RE: MOD 16 MP09_0066 THOMAS STREET CAR PARK SITE

The following provides a response to the issues raised by the Department and Willoughby Council in relation to the subject MOD application. Please also find amended plans accompanying this correspondence.

Centrium Journey Plan

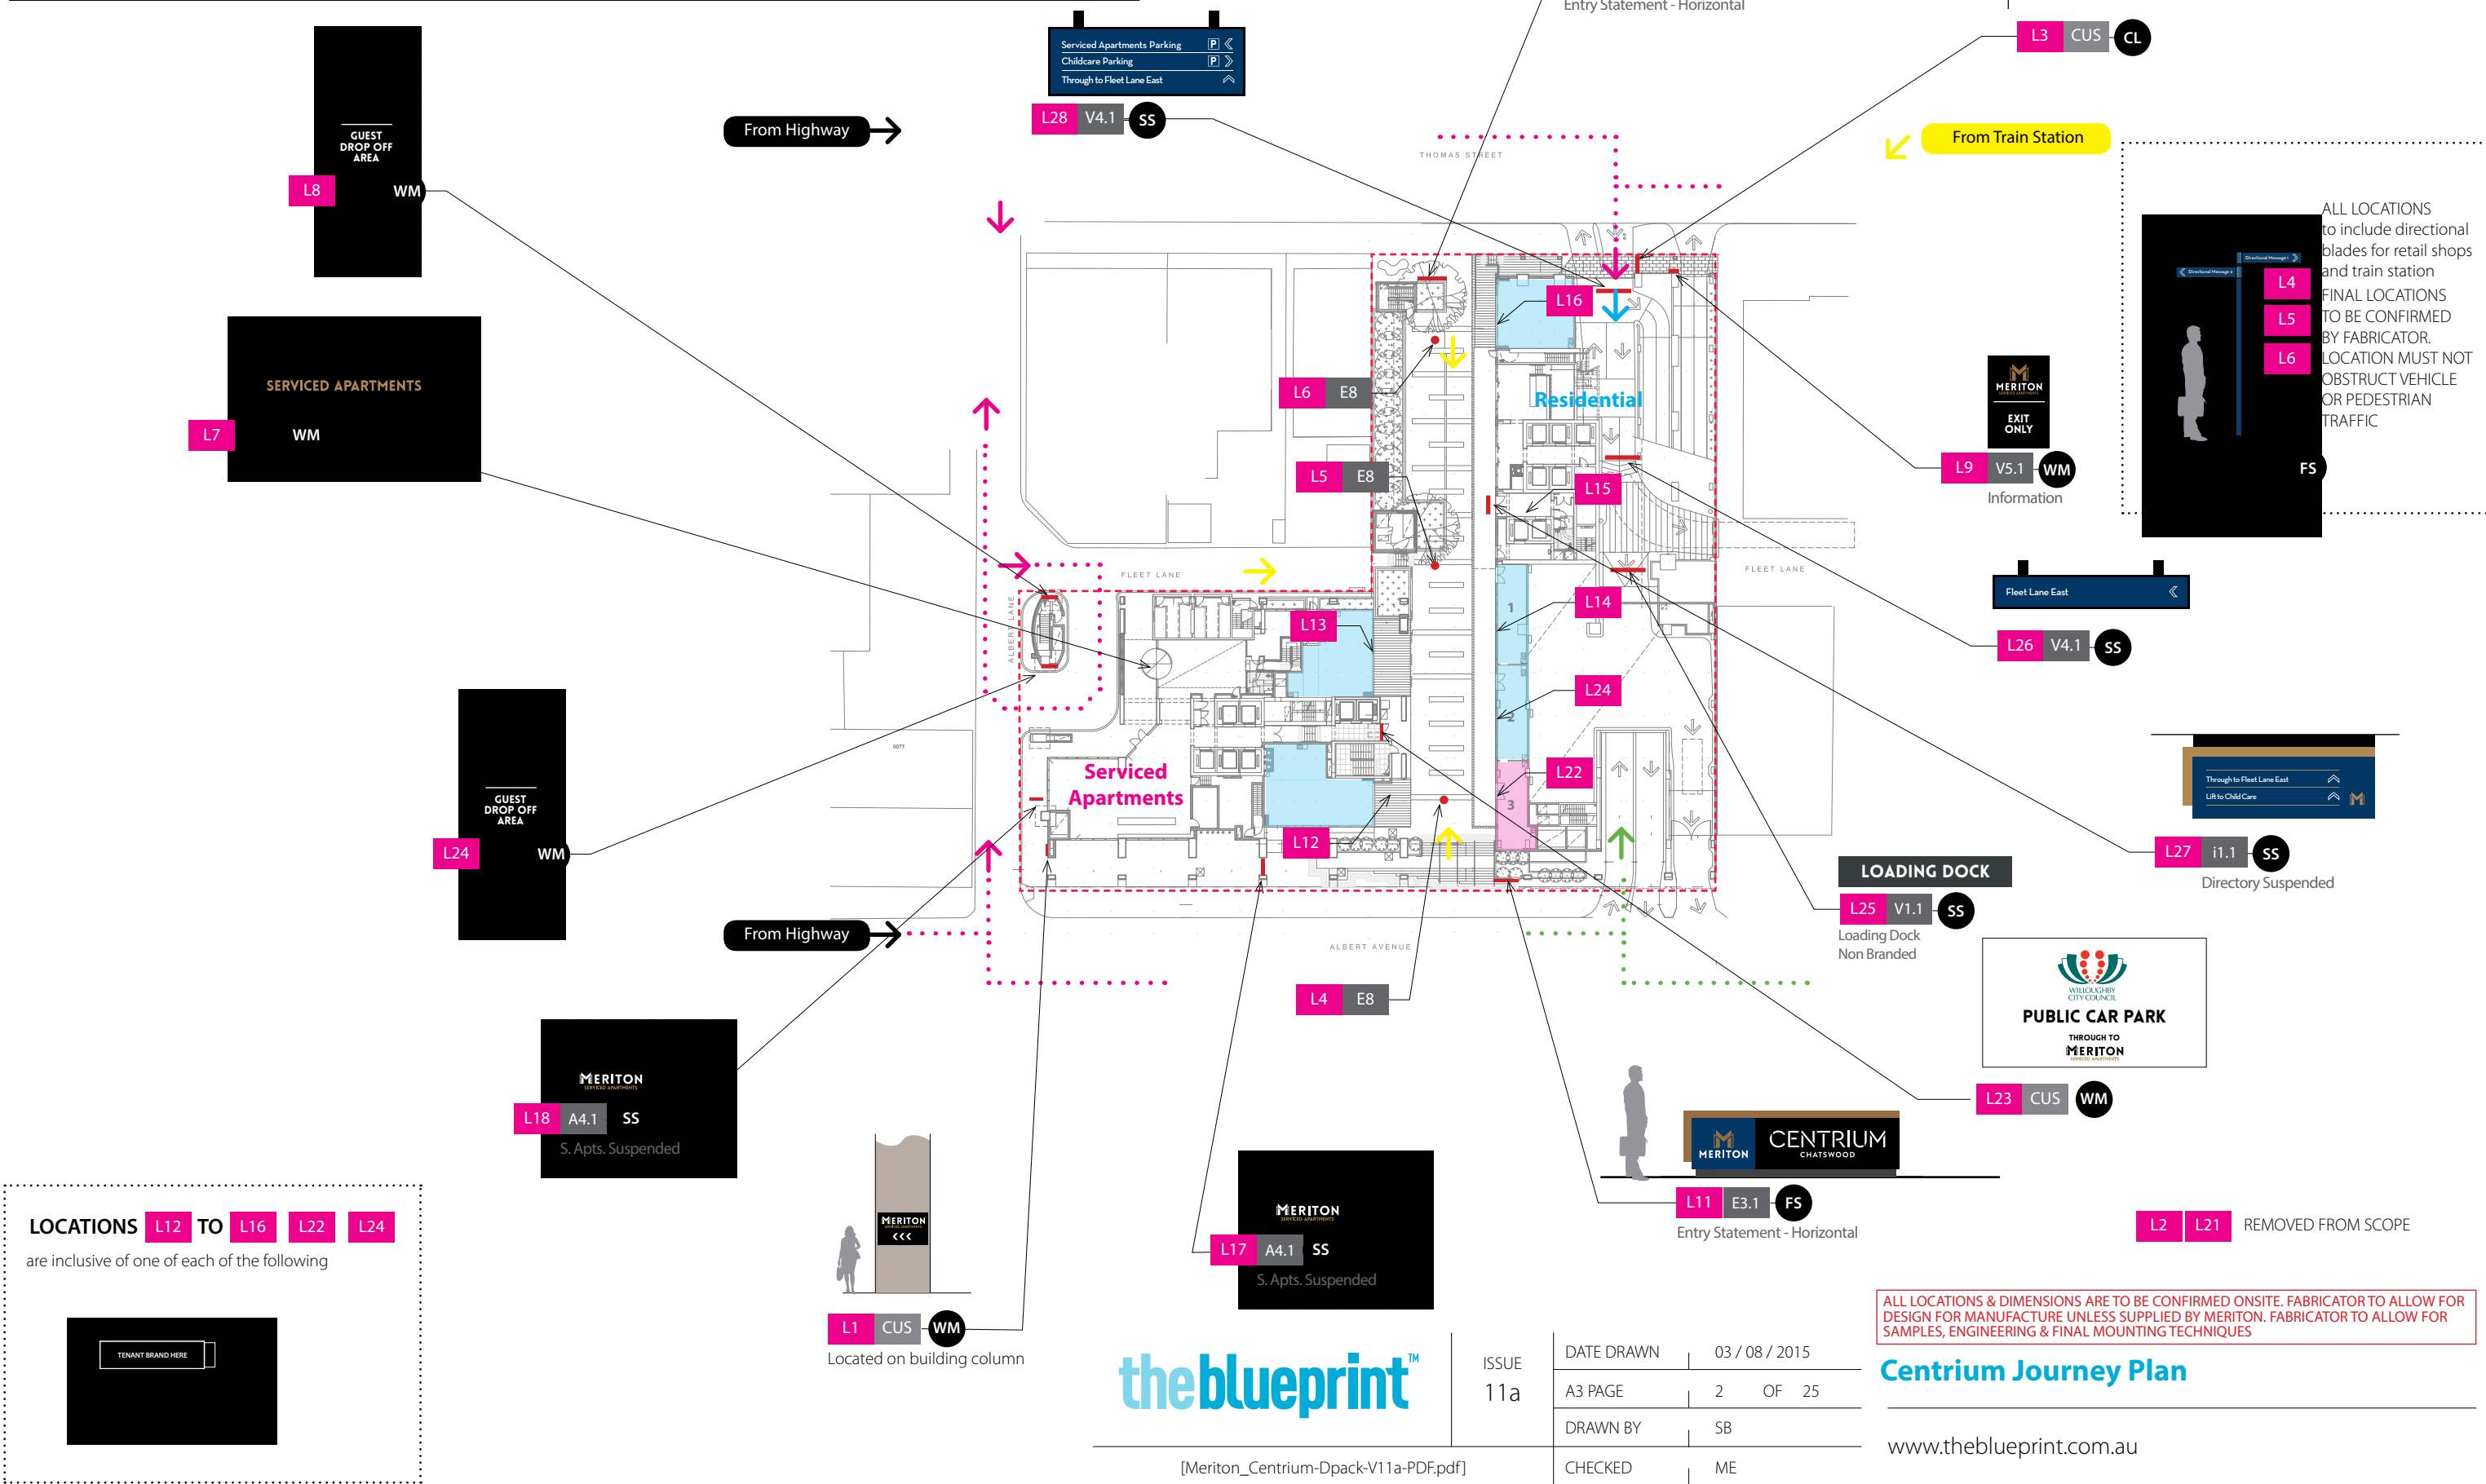
- *Are signs at locations L12 – 16, L22 and L24 each 2 signs? Therefore are there in fact 29 signs (not 22) proposed?*

- *Could you clarify what is proposed at L24? The description in the table in your report and information shown inside the box on Page 2 of the plans do not match the information in the central part of Page 2 or the information on page 19 of the plans.*

The number of signs has been clarified on the attached amended plan set.

The amended plan set clears up this anomaly. Under awning tenant sign only.

LOCATIONL1

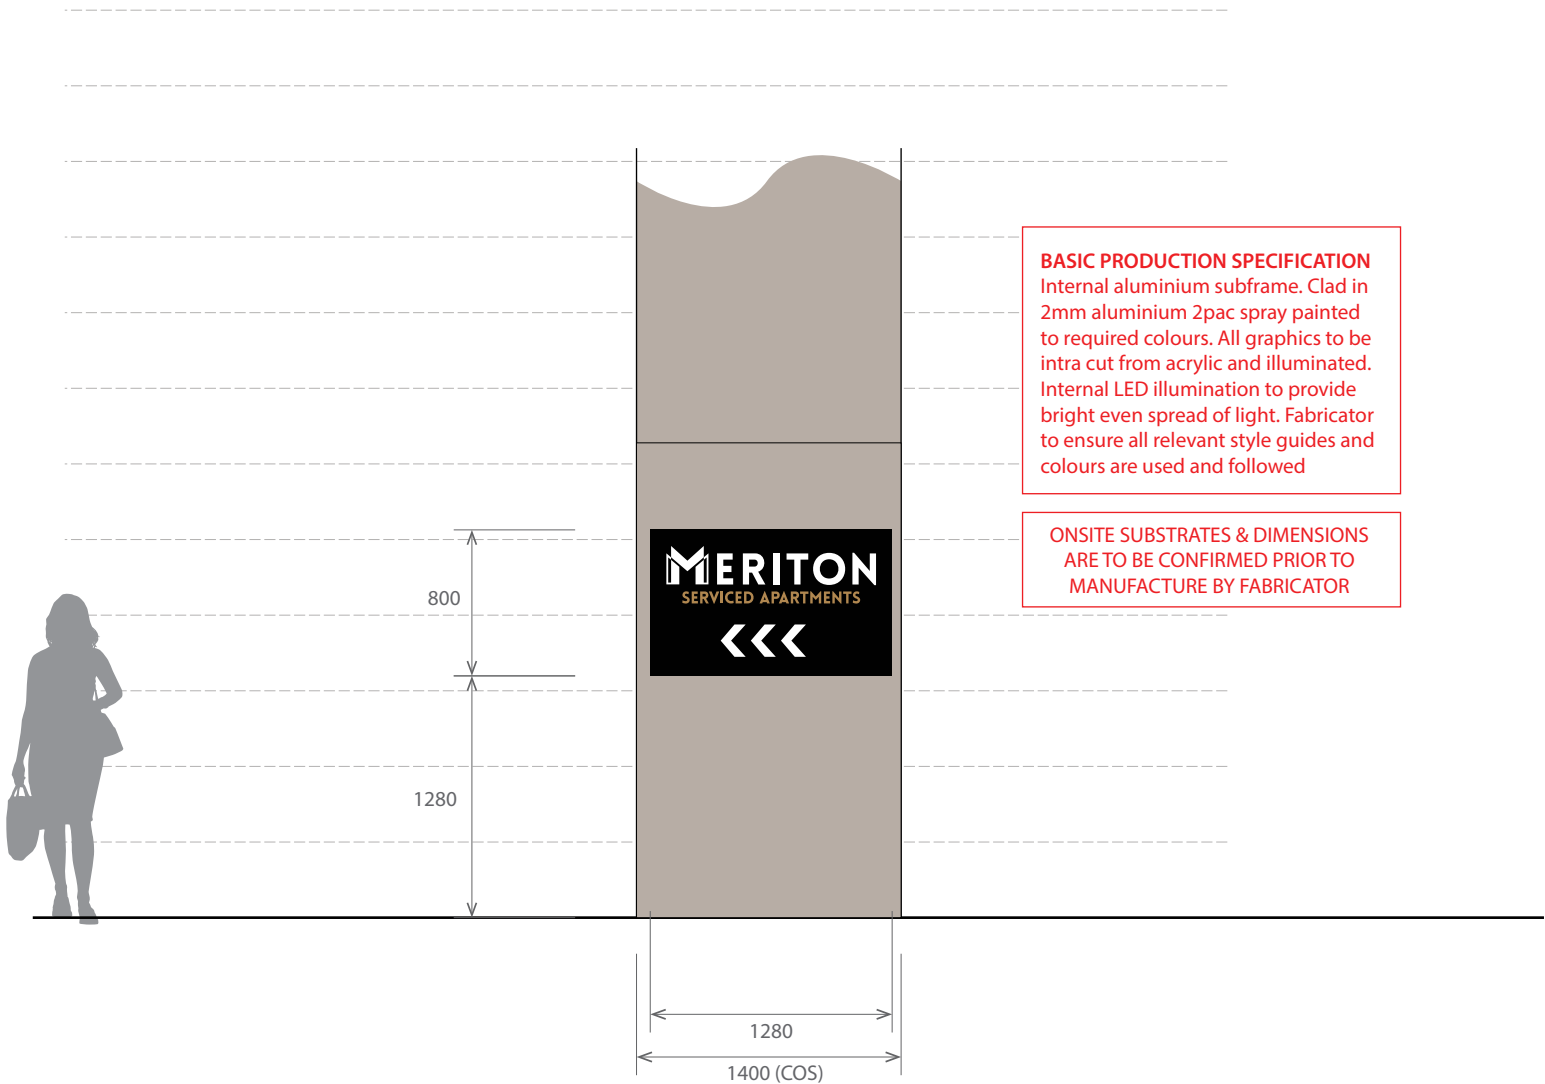
2. *Council has no objection to sign CUS in Location 1 subject to Location 1 being as indicated on Sheet 2 (9a) and not as indicated on the location view on Sheet 4 (9a).*

Noted. Location of sign now consistent.

L23

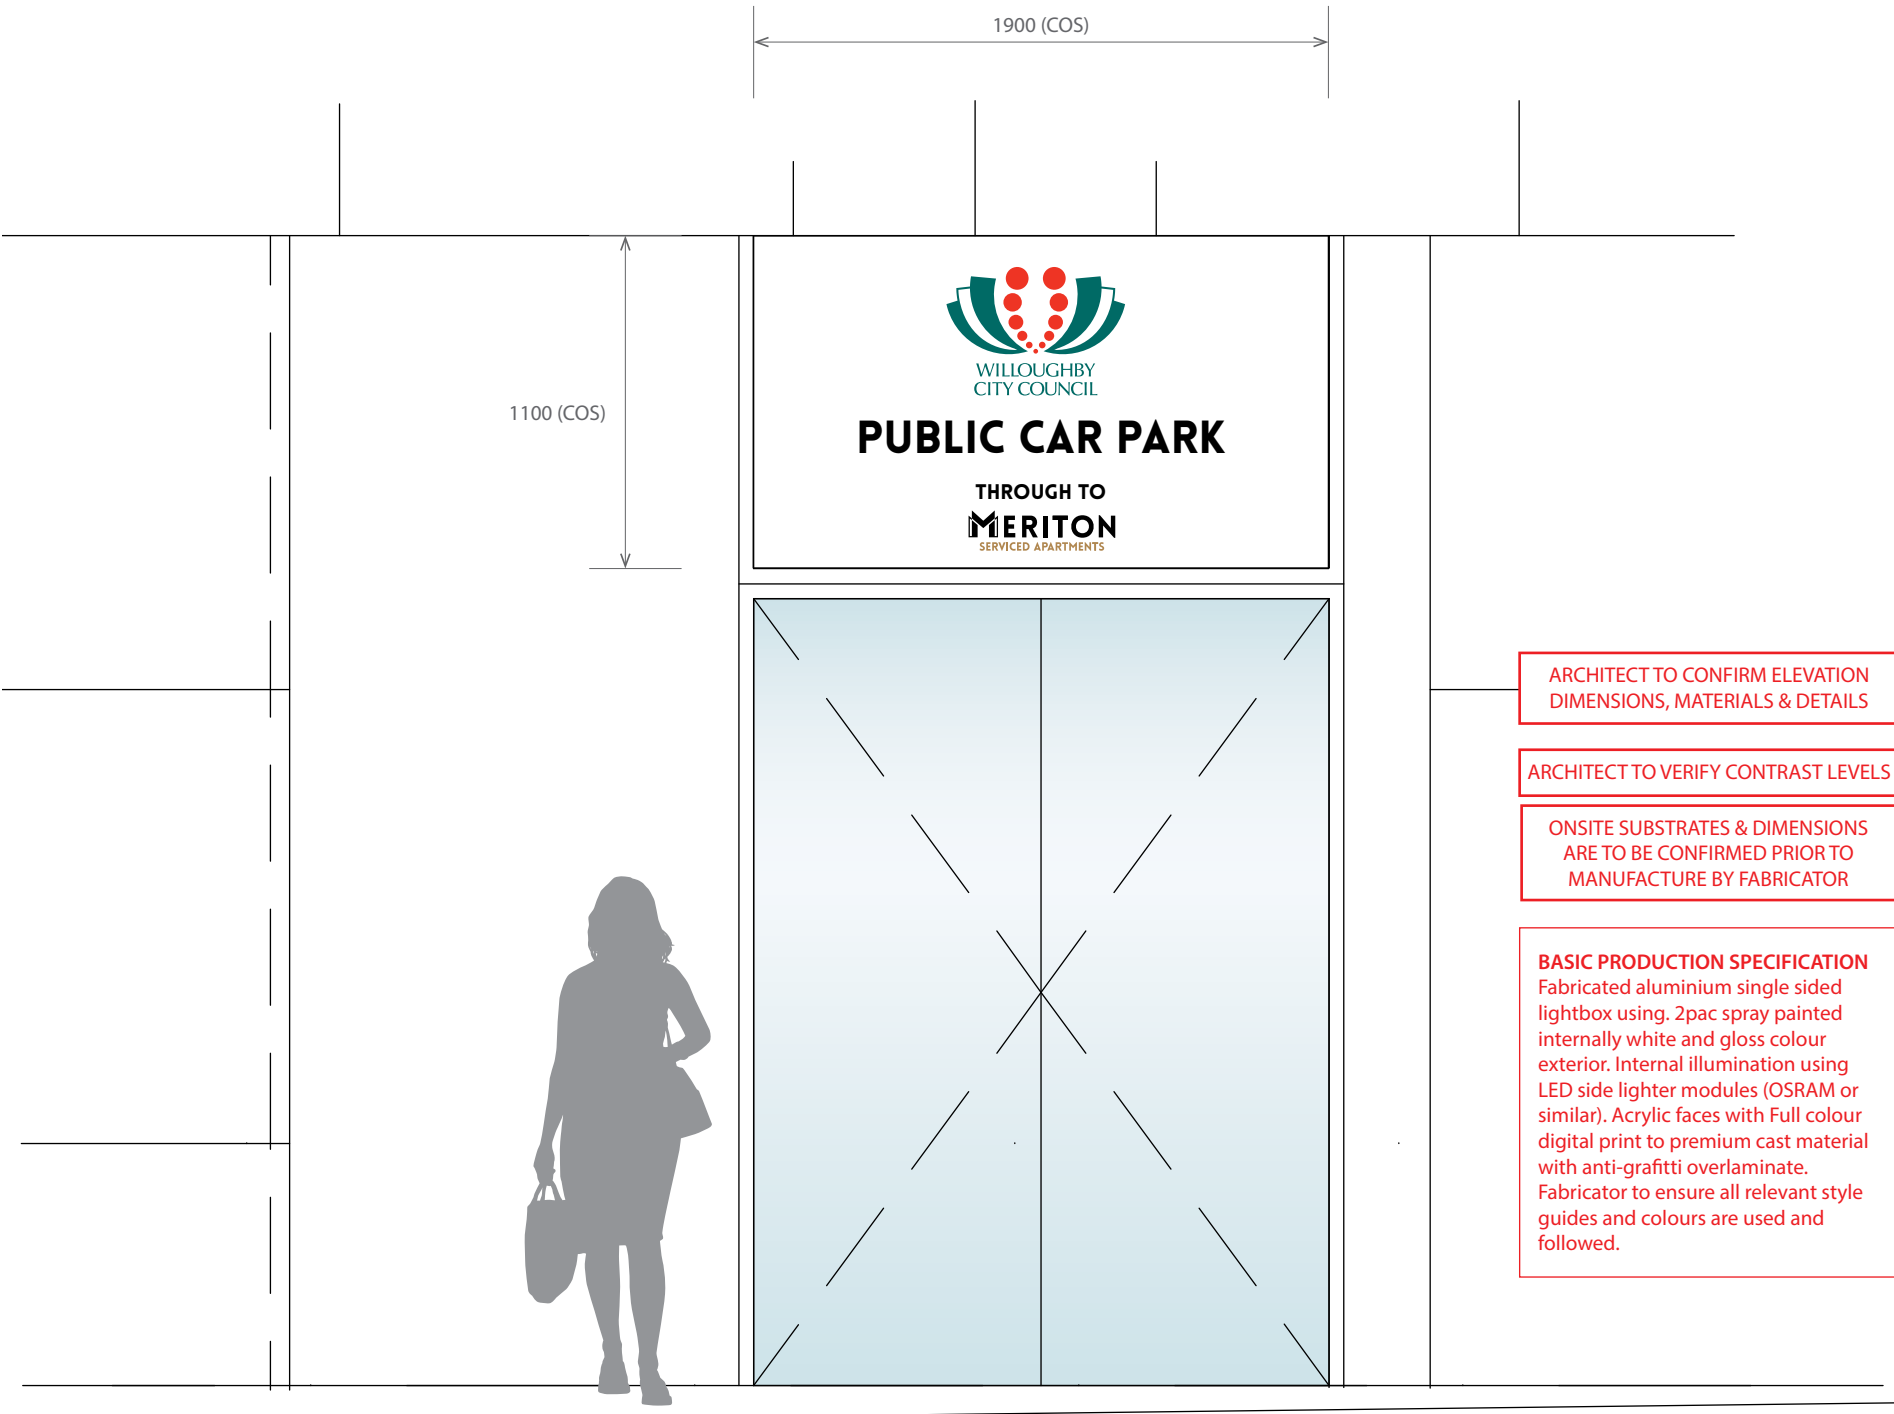
- Sign L3: External sign on Thomas Street that provides directions into and through the building.
 - Sign L28: Inside sign that provides directions to parking and Fleet Lane East
 - Sign L26: Inside sign that provides directions to Fleet Lane East
 - Sign L25: Loading dock sign.
7. *The pedestrian entry and lift foyer to the public car park from the plaza, Sign A1.2 in Location L23, requires the addition of the Willoughby Council logo. The words should read "Public Car Park" under the Council logo and then "Through to Meriton Serviced Apartments" [that is, the image for Meriton serviced apartments].*

Sign L23 has been amended as required above.

LOCATIONL25

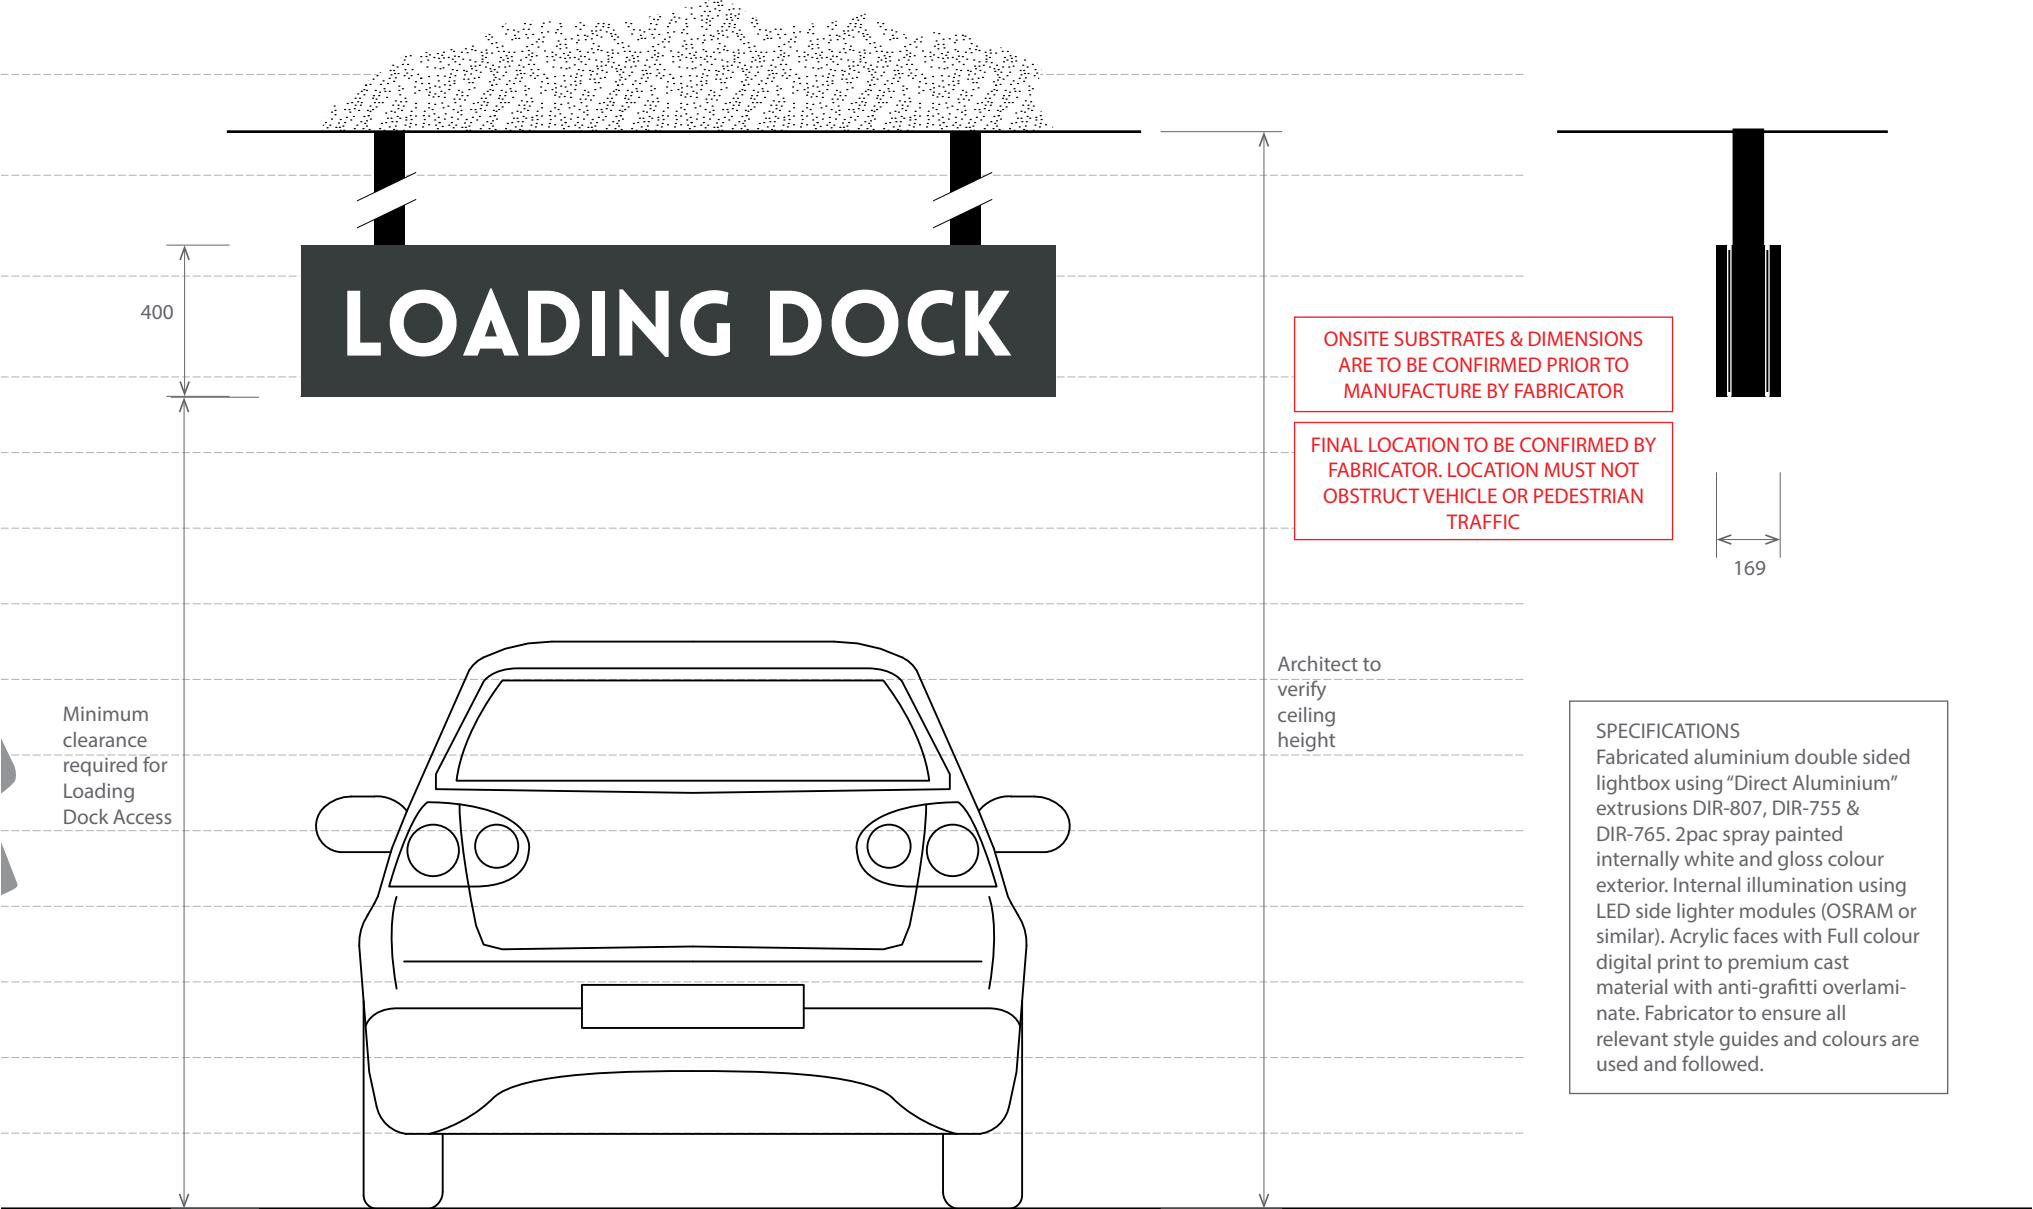
6. *The signage at the entrance to the Fleet Lane East Link, loading dock and Serviced Apartment parking needs further work. The single entrance has a number of destinations that need to be identified without confusion. Additionally on entry to the site the driveway to the serviced apartment parking is immediately located on the left side. It needs additional identification given the potential for confusion of tourists missing the entry. For this reason the Sign V3.1 in Location 3 is not supported. The "Loading dock" sign is also not supported in its current form. Consideration should be given to identifying the entry as the "Fleet Lane East Link". A wall sign beside the entry can provide the sign age for "Meriton Serviced Apartments" image without the blue "P" as that suggests broader public use. Immediately within the site on the left side driveway entry column signage can provide an arrow and "Meriton Serviced Apartments Parking". Further on within the Link Road the loading dock entry can be identified above the roller door. Council considers that the rationalisation will mean directional advice for deliveries and visitors to the site will be made easier by a single reference to enter via the Fleet Lane Link. The signage can be supplemented at the entry by a standard Council street sign in Thomas Street at the kerb if required and installed by Council.*

The signage has been configured as follows:
